**1st REVIEW – DEVELOPMENT PLAN – APPROVED WITH CORRECTIONS
CIMARRON HILLS FIRE PROTECTION DISTRICT (CH2017-14-DP-1)**

FILE NUMBER: PPR-17-020

On Tuesday, May 9, 2017 the Cimarron Hills Fire Department submitted a development plan to PEAK Consulting Services, Inc. for a fire code compliance review of a proposed commercial lot for the **NEW MEADOWBROOK MINI-STORAGE FACILITY** located at **### Meadowbrook Parkway** within the Cimarron Hills Fire Protection District.

SITE PLAN
 SCALE: 1"=30'-0"

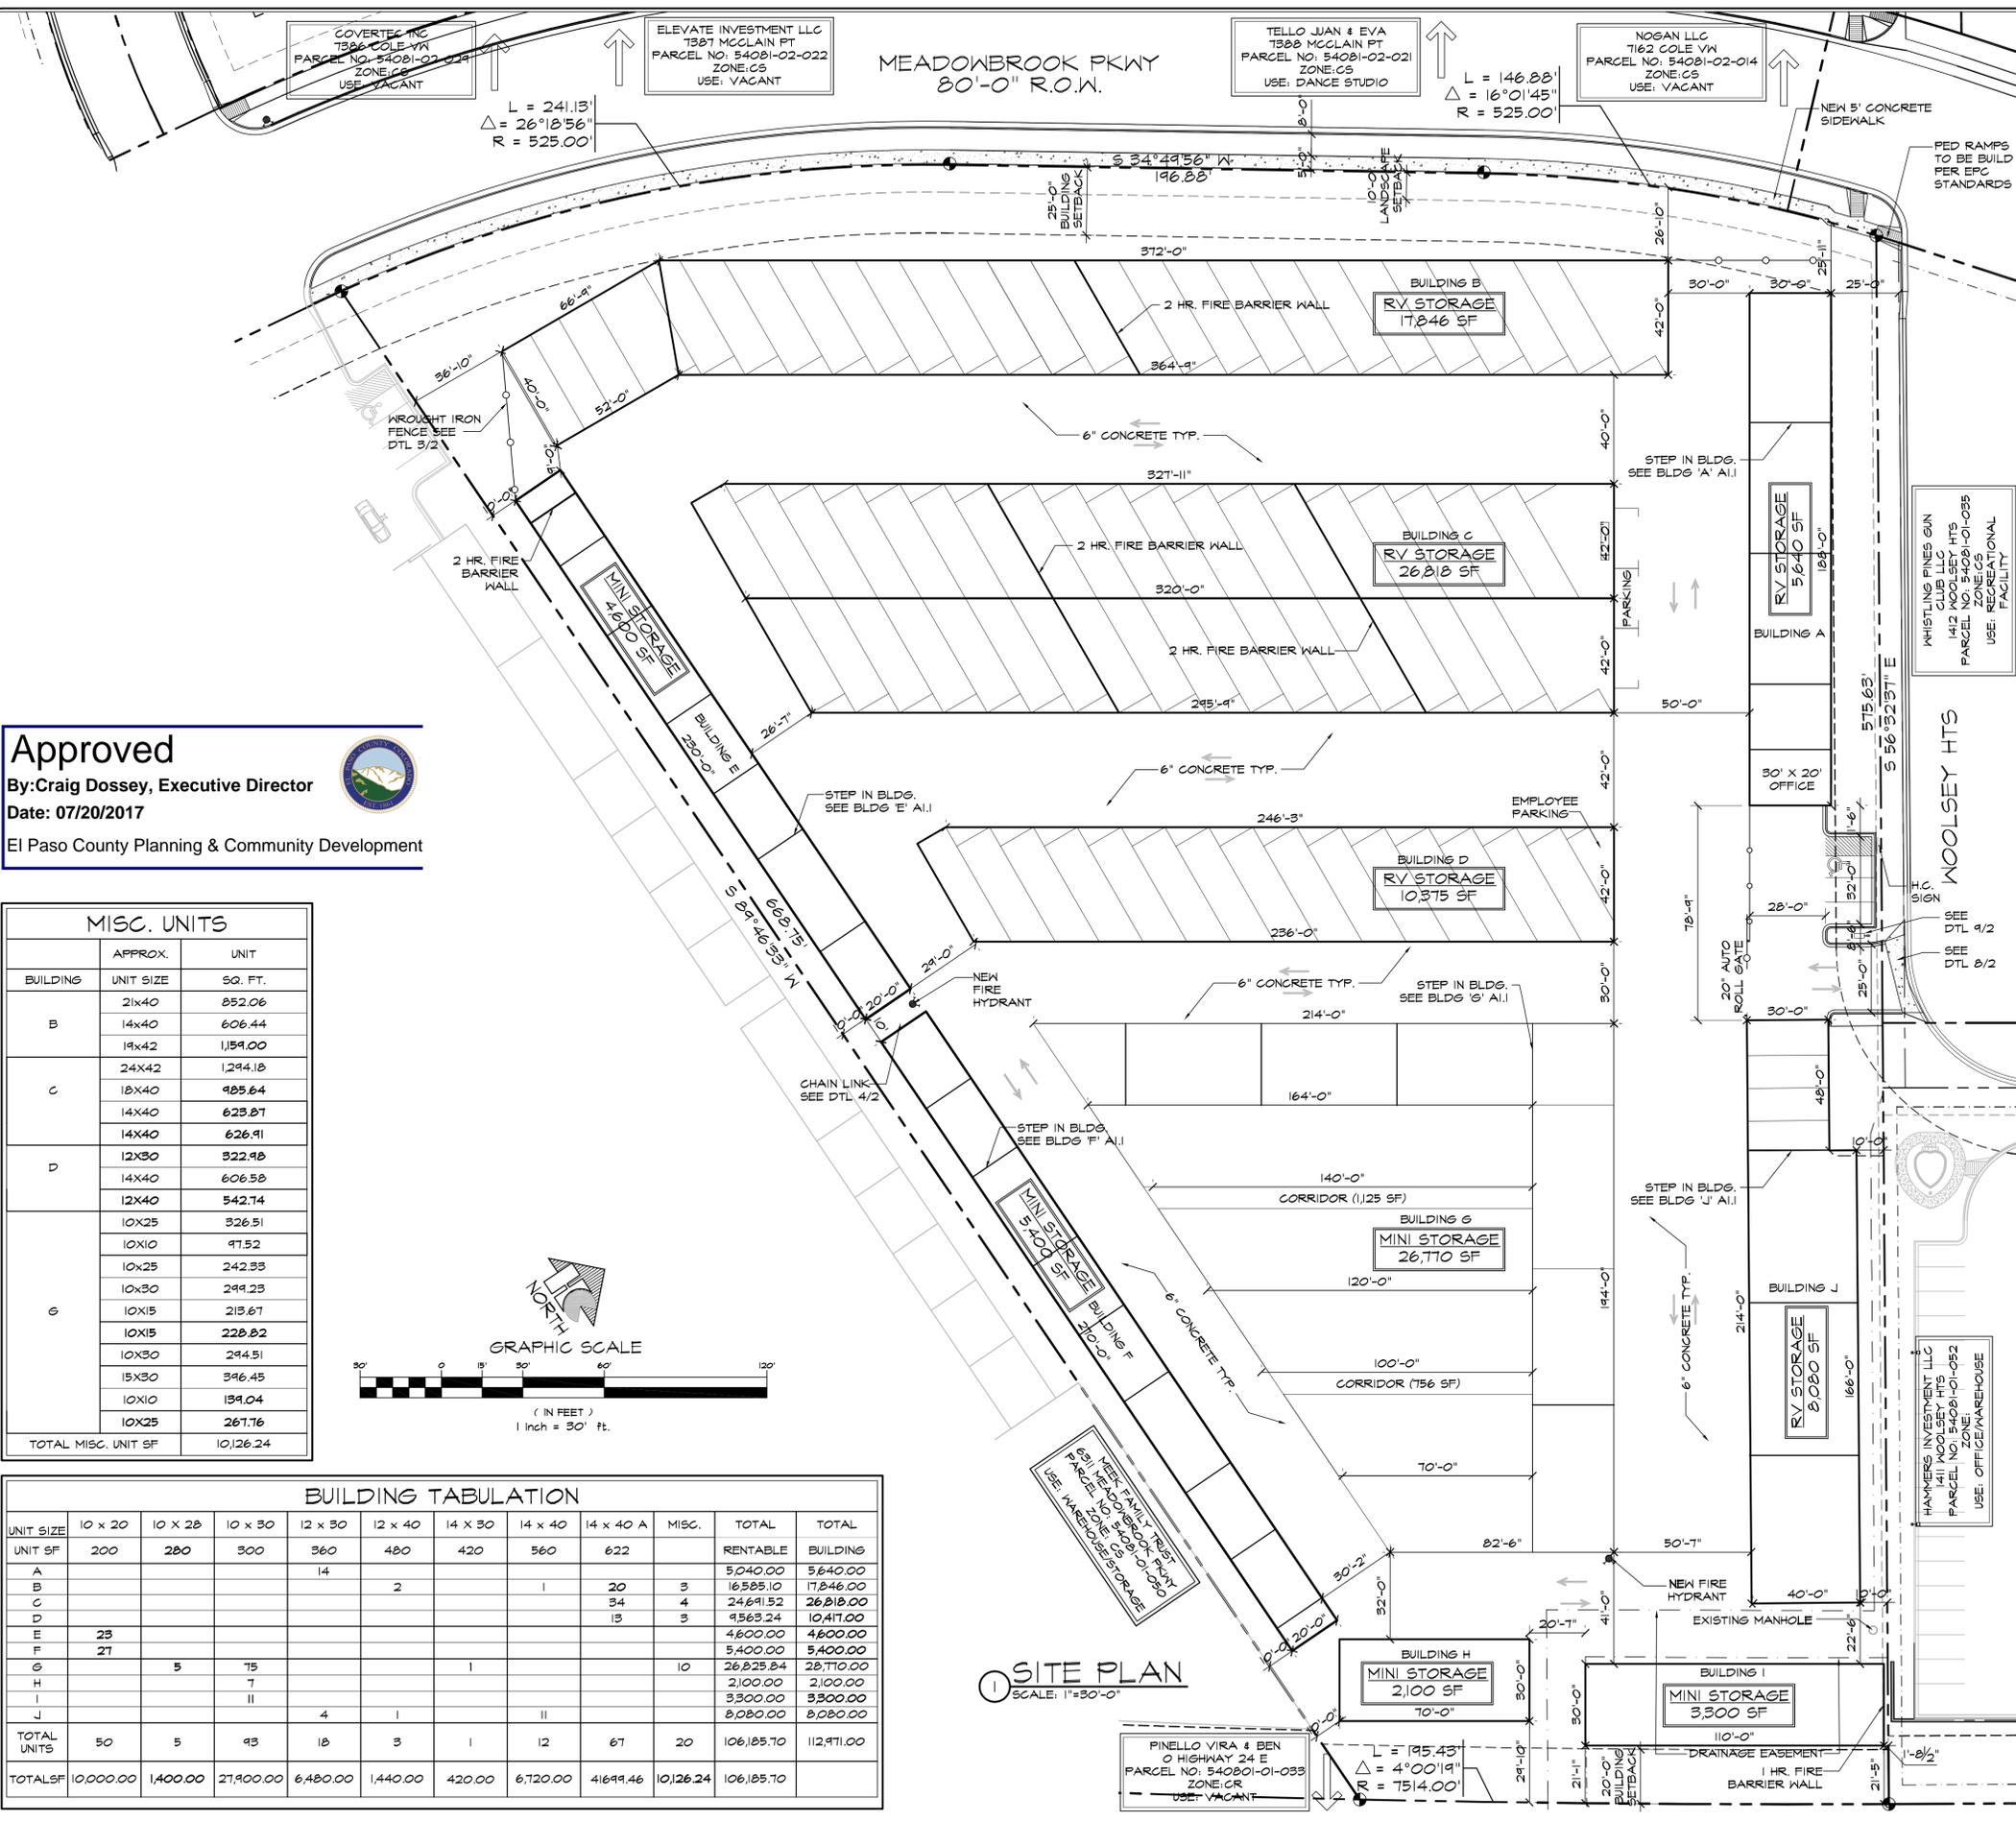
- 1) **KNOX ENTRY** – This facility will have a secure entry electric gate. This gate SHALL be equipped with a KNOX™ Key Switch.
- 2) **TURNING RADIUS** – The East End of this development indicates that there will be RV parking. NOTE: Turning Radius requirements shall be maintained and not impeded upon parked RV's.
- 3) **FIRE HDRANTS** – Fire hydrants/water supply shall be provided in accordance with the IFC.
